Response to Planning Application

Application ref: M/63/21/DOC

Description: Approval of details reserved by condition imposed under ref M/32/19/PL relating to Condition Nos 4 - landscaping, 7 - wildlife habitats & enhancements and 8 - wildflower meadow planting

Location: 46 Sea Lane Middleton-On-Sea PO22 7RX

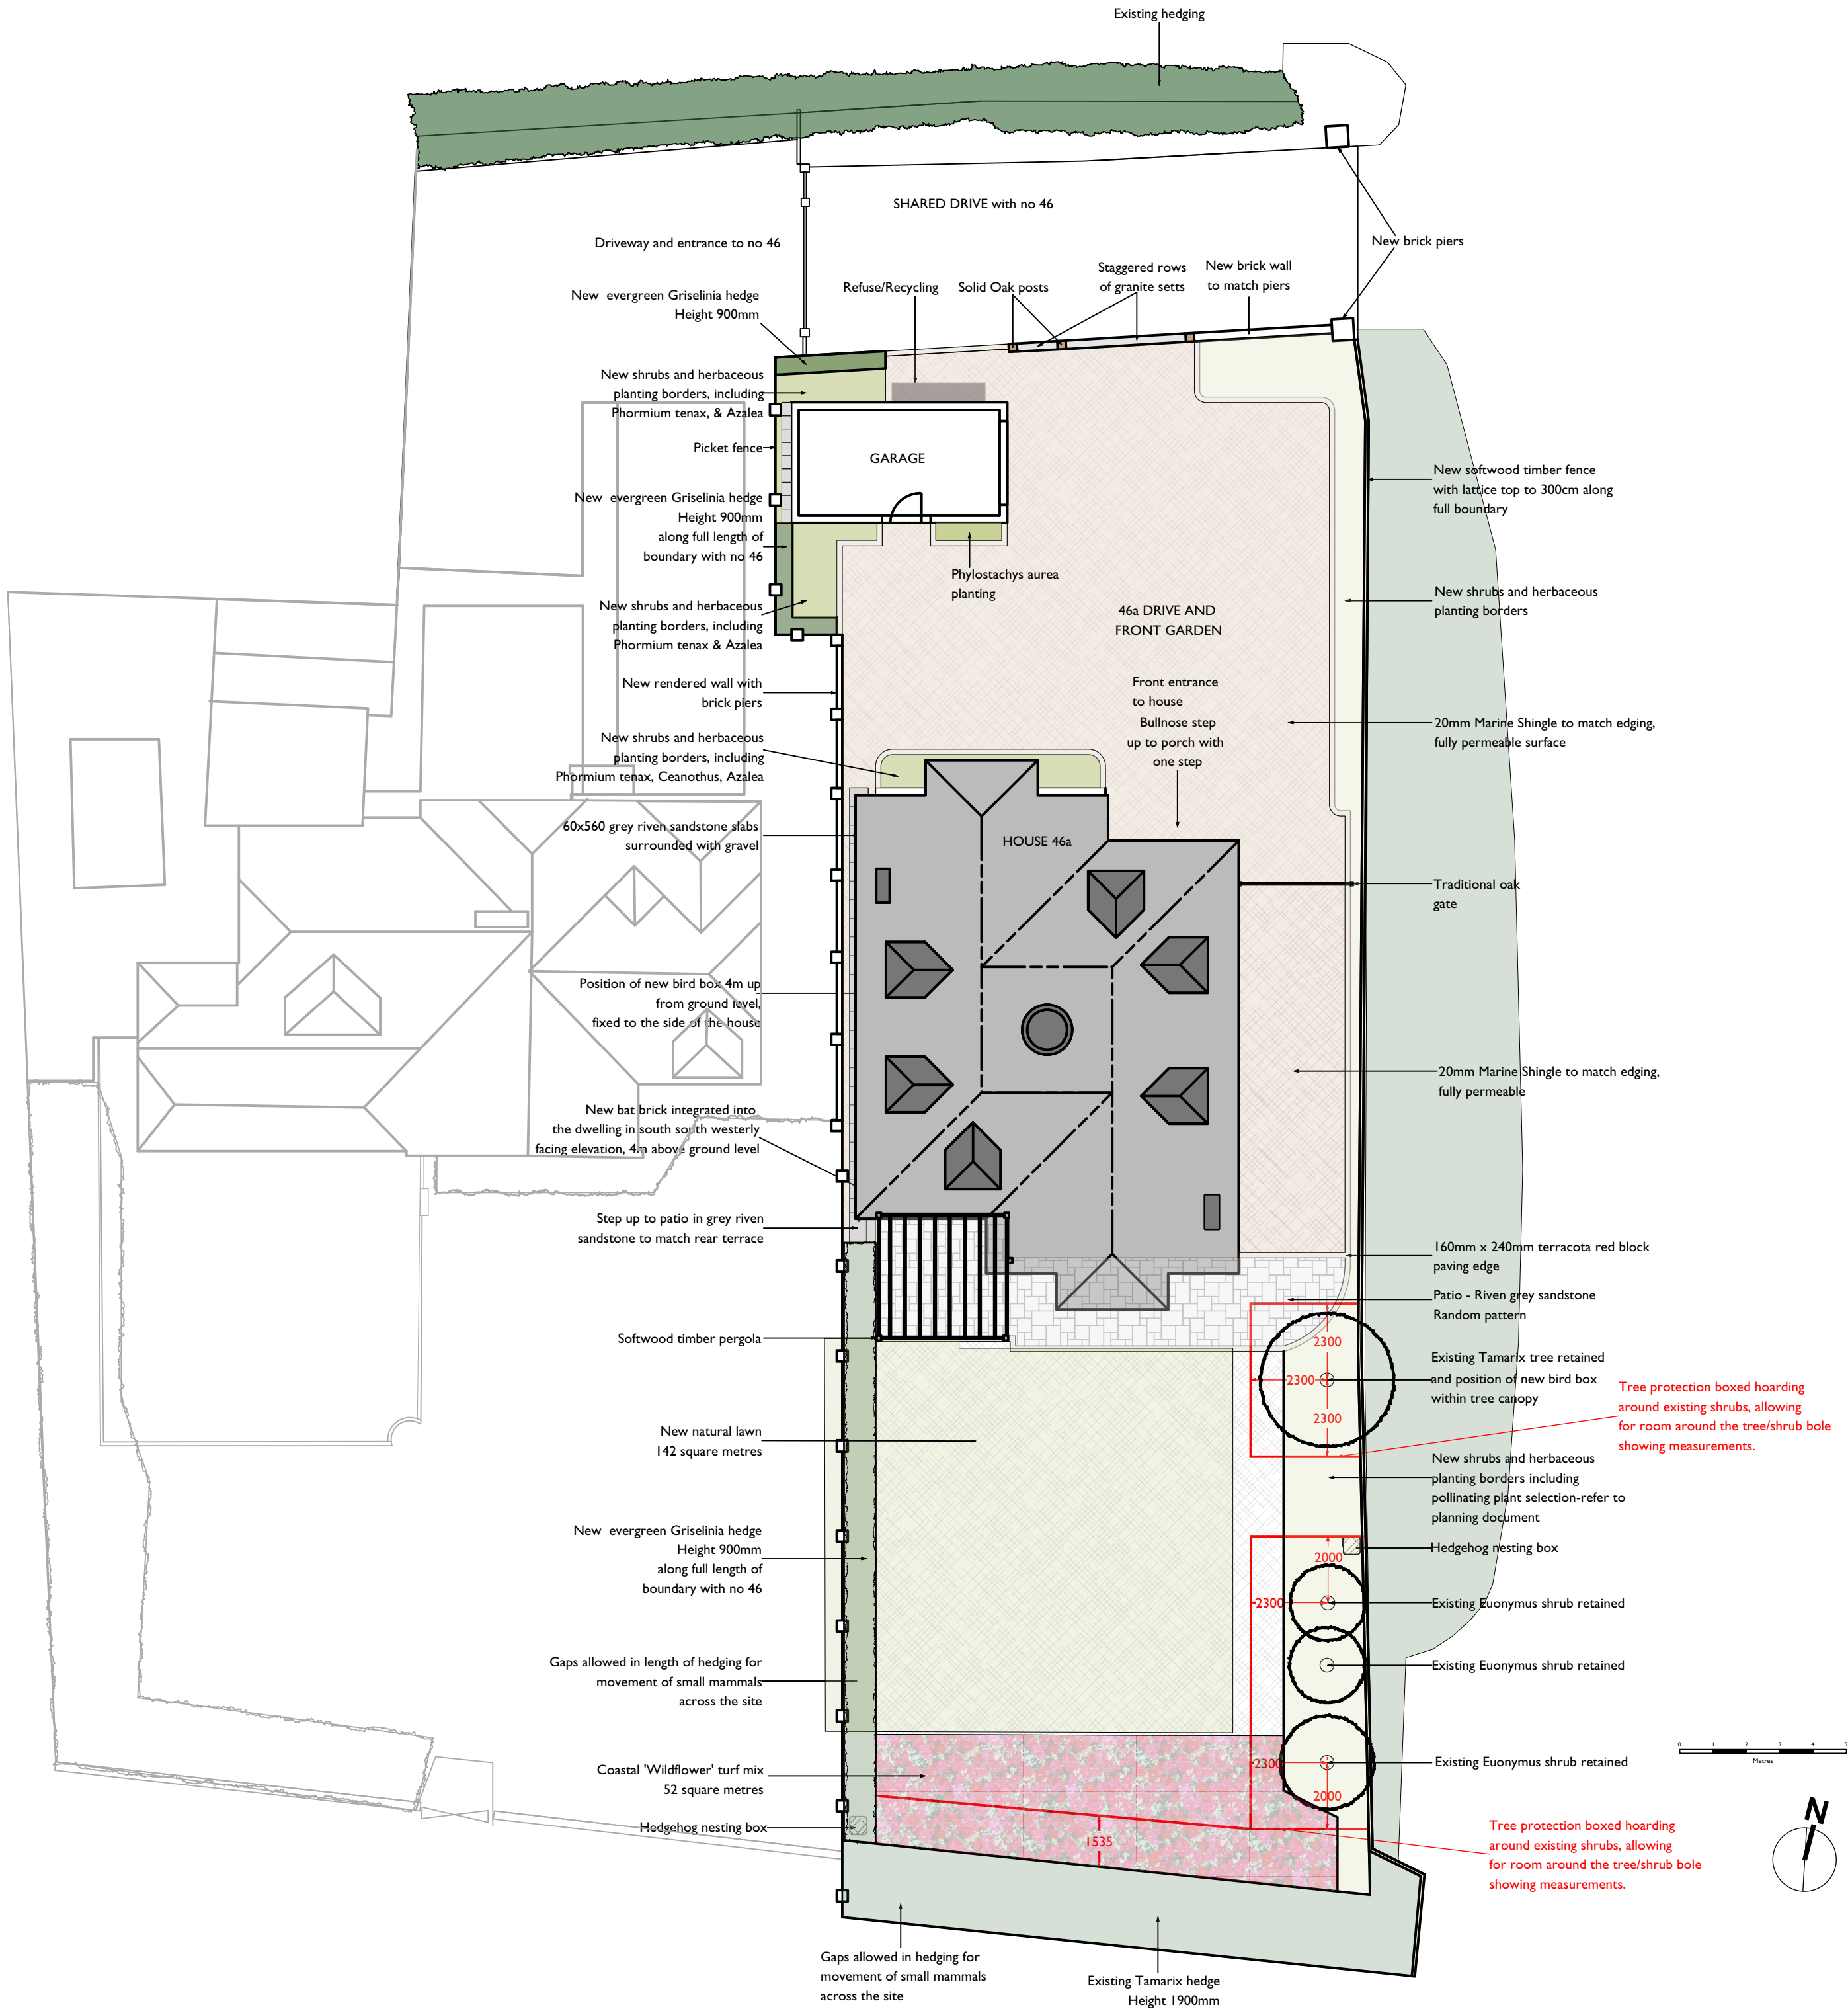
The proposed landscape detailed in Landscaping layout detail Dwg 46aSLMOS/01 proposes a scheme which provides detail of planting which would be appropriate for location in species choice. Further information requested re actual quantities for each area including hedging and specific planting detail rather than the shown as 'including..... new shrubs and herbaceous planting borders. Actual mix and numbers and planting density to be shown in plan form.

Recommend **further detail to be provided** as above re specific planting mix and quantities before discharge of Condition 4 could be recommended.
